SERVICE PLAN COMMENTS

EXHIBIT A-3 PROPOSED INFRASTRUCTURE AND AMENITIES MAP

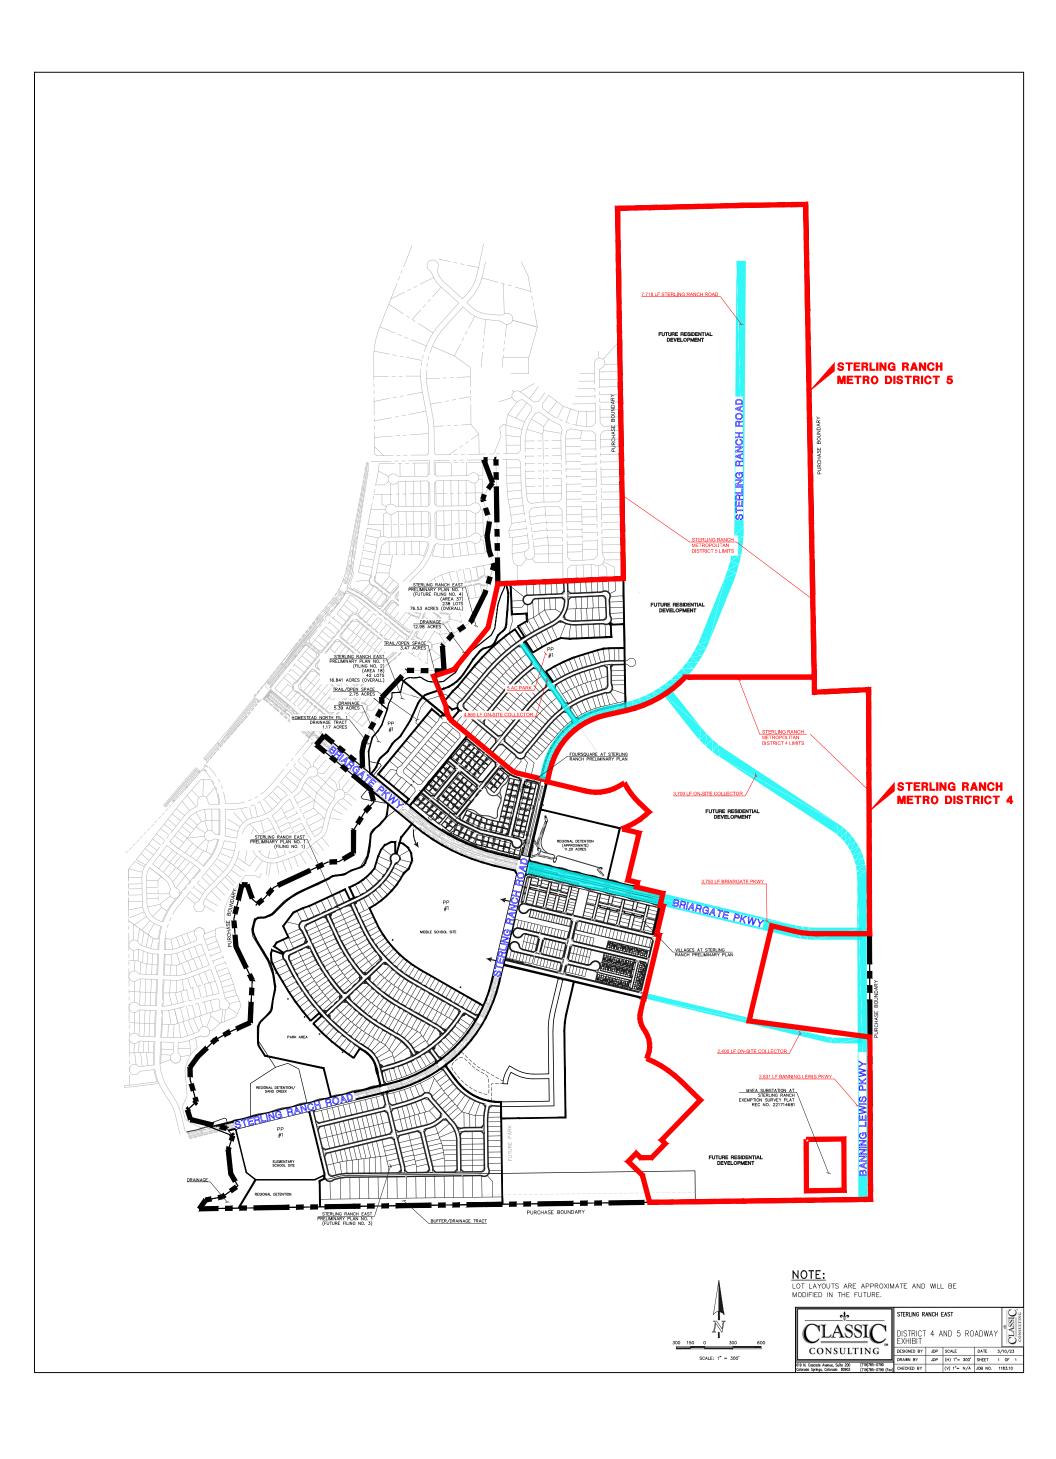
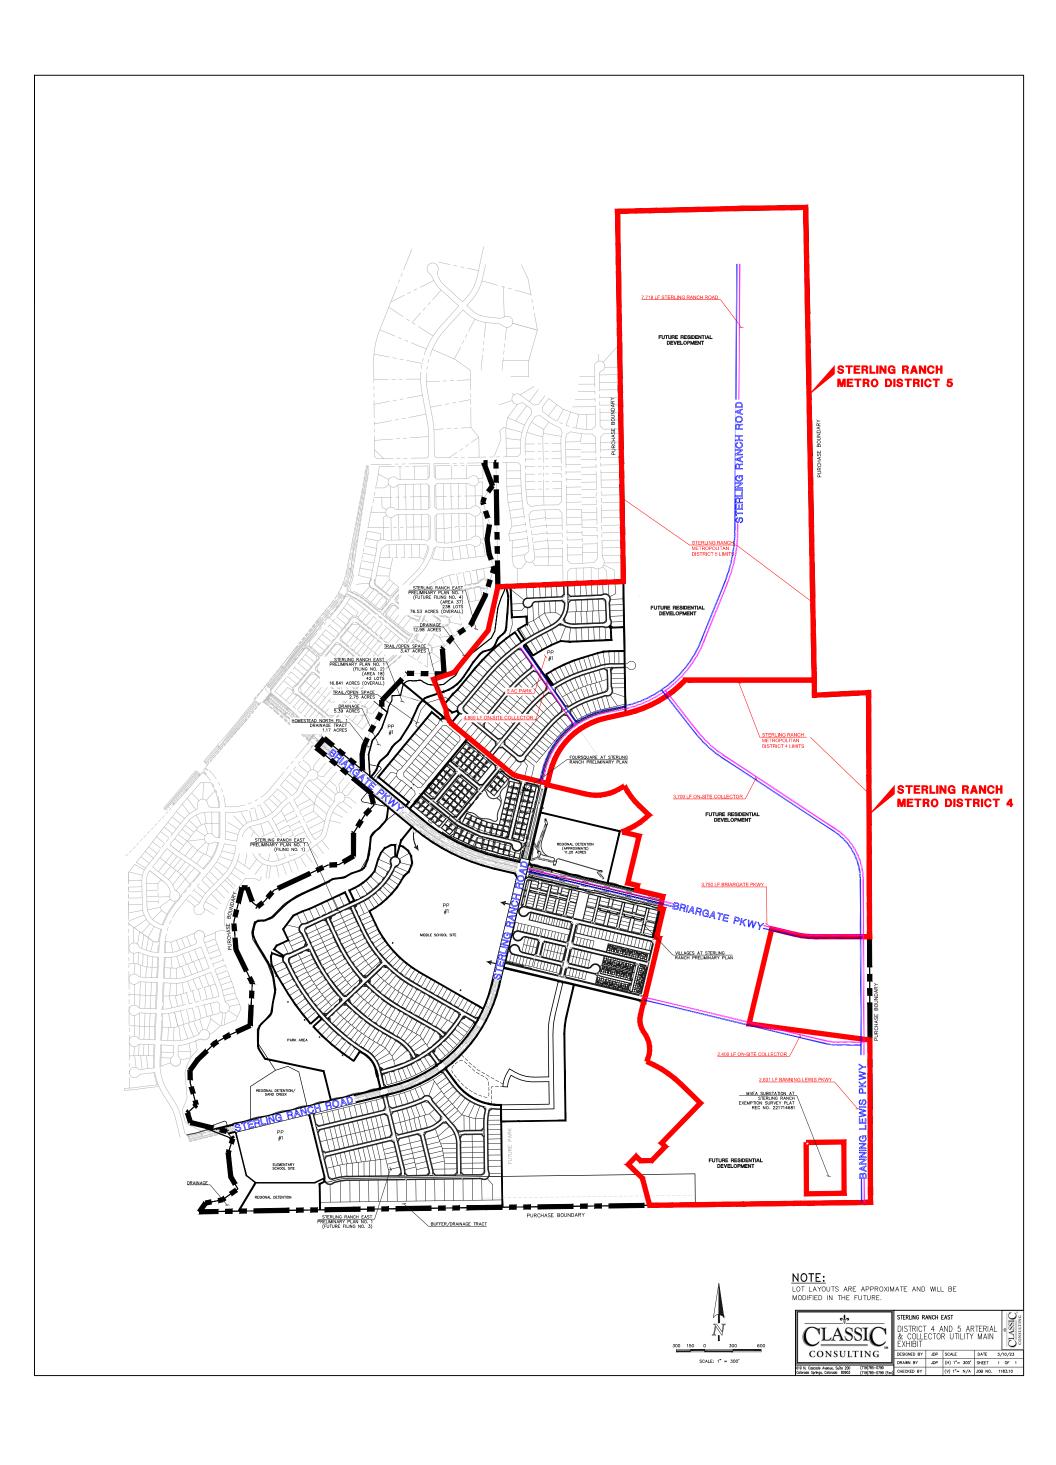
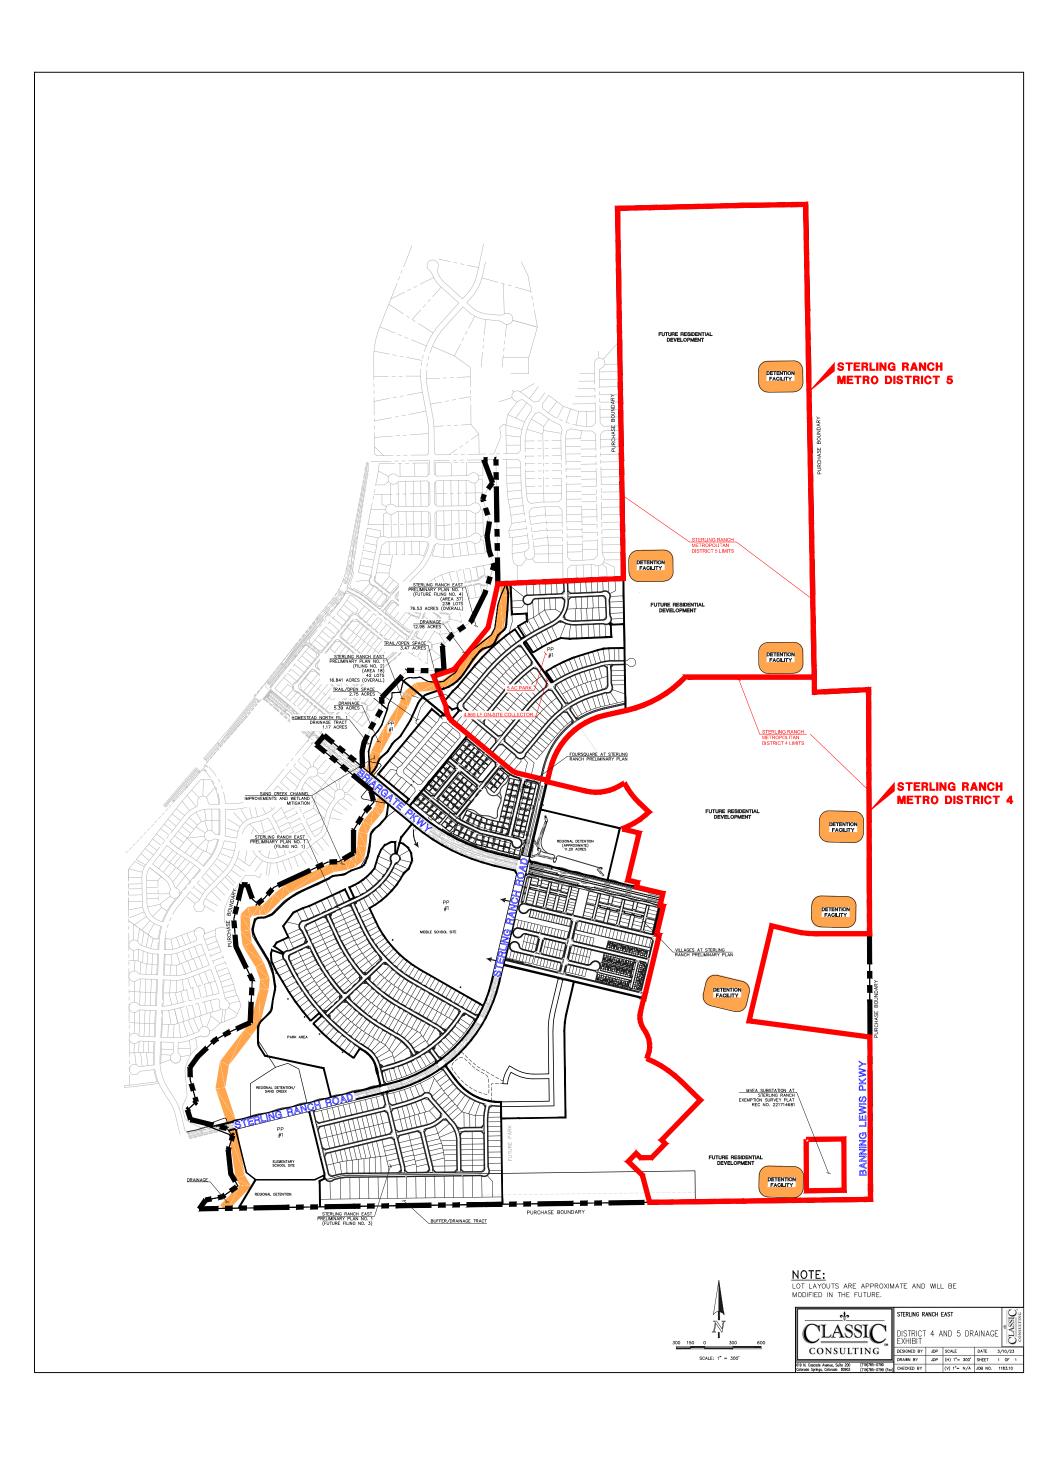
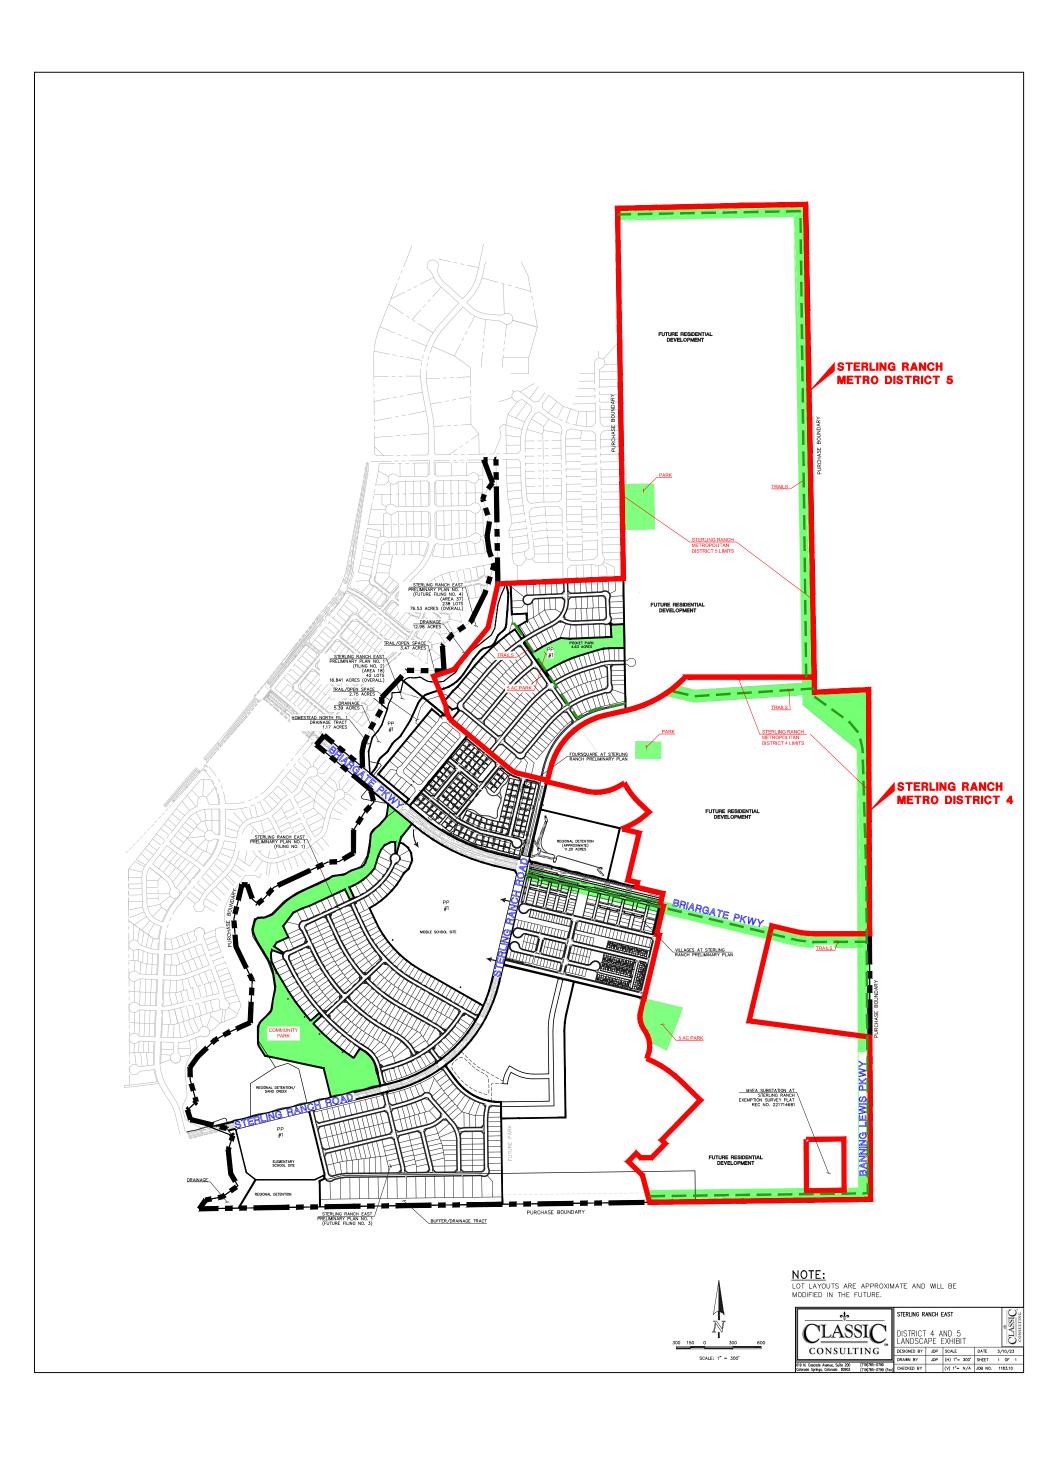
30.	Exhibit A-3 – Provide the basic improvement maps (water, wastewater, streets, utility, open space/trails, stormwater and drainage)	Revised.
31.	Exhibit A-4 – Need a more detailed map of future inclusion area that better depicts surrounding area	Revised.
